Memorandum

Subject: **Conditions of Approval**
Site Plan – EPC, Major Amendment
Plan #SP-2025-00041

Conditions of Approval – Project #: SP-2025-000041 - Site Plan-EPC, Major Amendment

1 Proposed Changes:
1. Indicate Tract B as "NOT A PART" on Sheet 1 of 3 as it is being repealed from the Site Plan.
2. Indicate Tract A as "NOT A PART" on Sheet 3 of 3 as it is being repealed from the Site Plan.

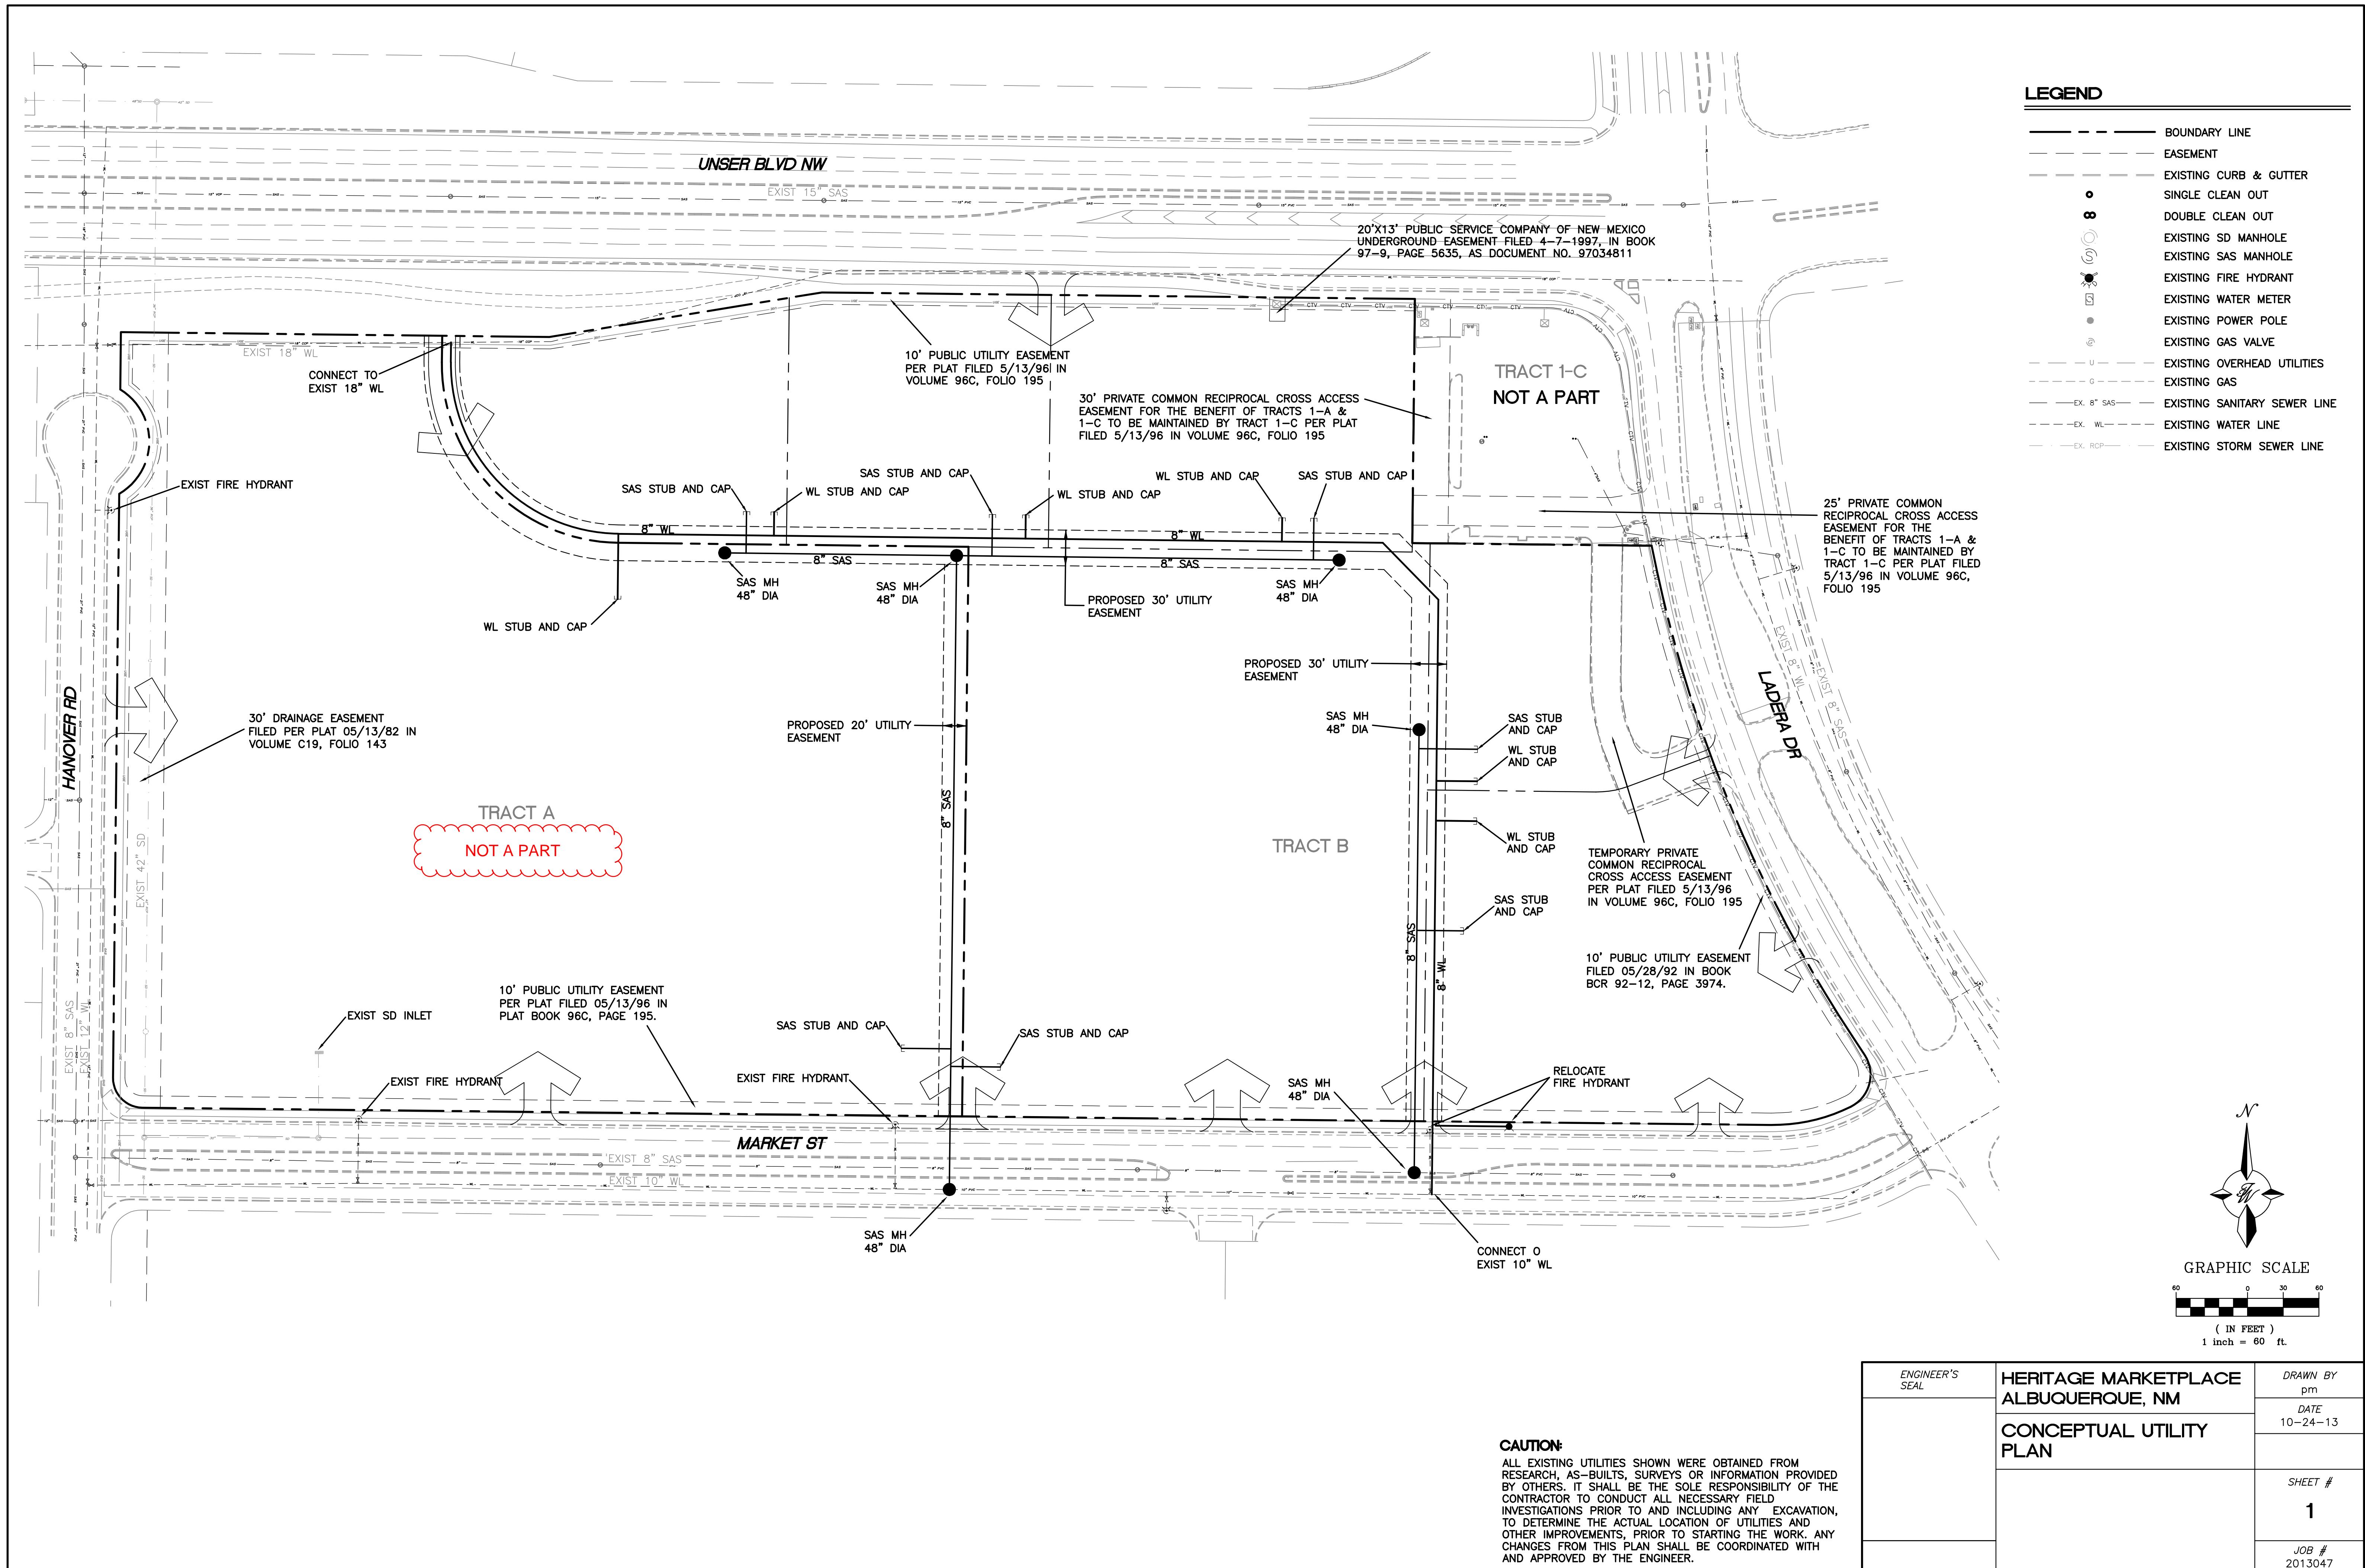
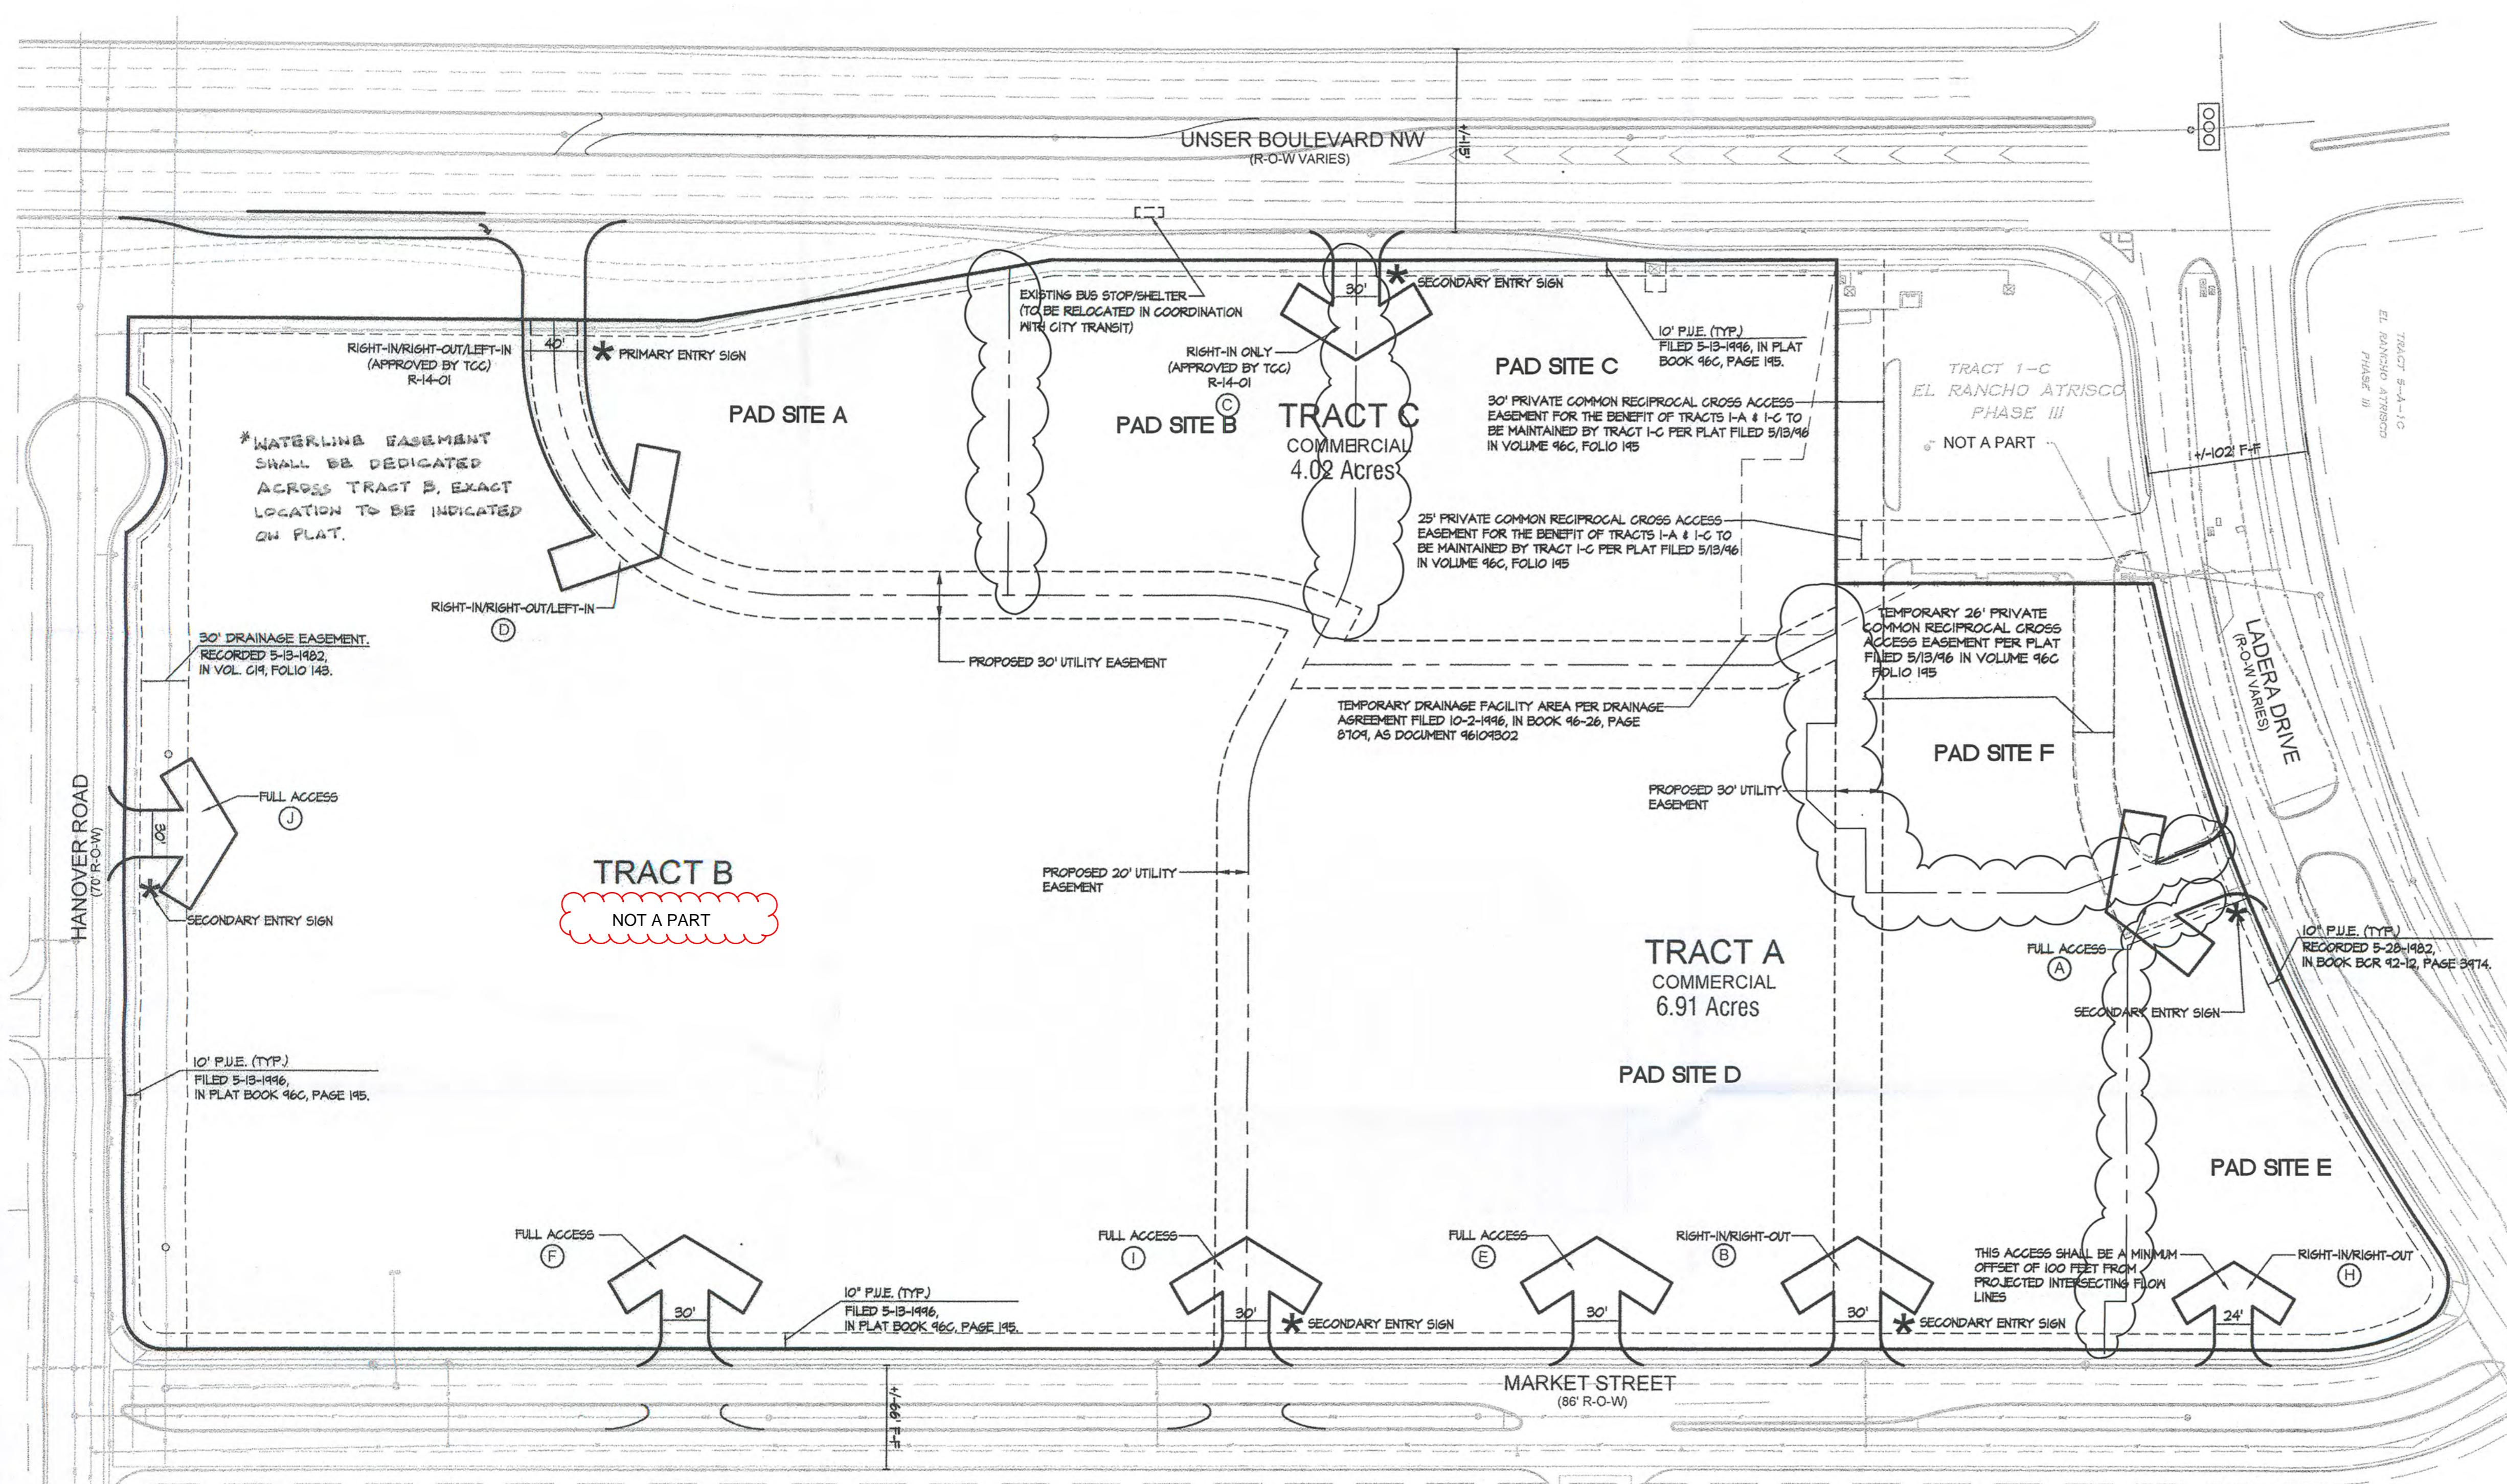
6. The text as part of “Proposed Changes: 2.”, as shown on Sheet 1, shall be removed as it is not applicable.

- a. “Proposed Changes: 2” referenced Sheet 3, which has been removed. As a result, the provisions of “Proposed Changes: 2” are no longer applicable and this clause has been deleted.

7. The Site Plan for Subdivision boundary shall be updated to show its new extent without Tract B.

- a. Tract B is now designated as “NOT A PART” of the Heritage Marketplace Site Plan for Subdivision on Sheet 1 of 2 (see attached revised sheets).

- 5. Heritage Marketplace Site Plan for Subdivision page numbers shall be updated to reflect 2 sheets (1 of 2, 2 of 2).**
 - a. The Heritage Marketplace Site Plan for Subdivision has been updated to reflect the removal of the third sheet. The remaining sheets are now numbered 'Sheet 1 of 2' and 'Sheet 2 of 2' (see attached revised sheets).
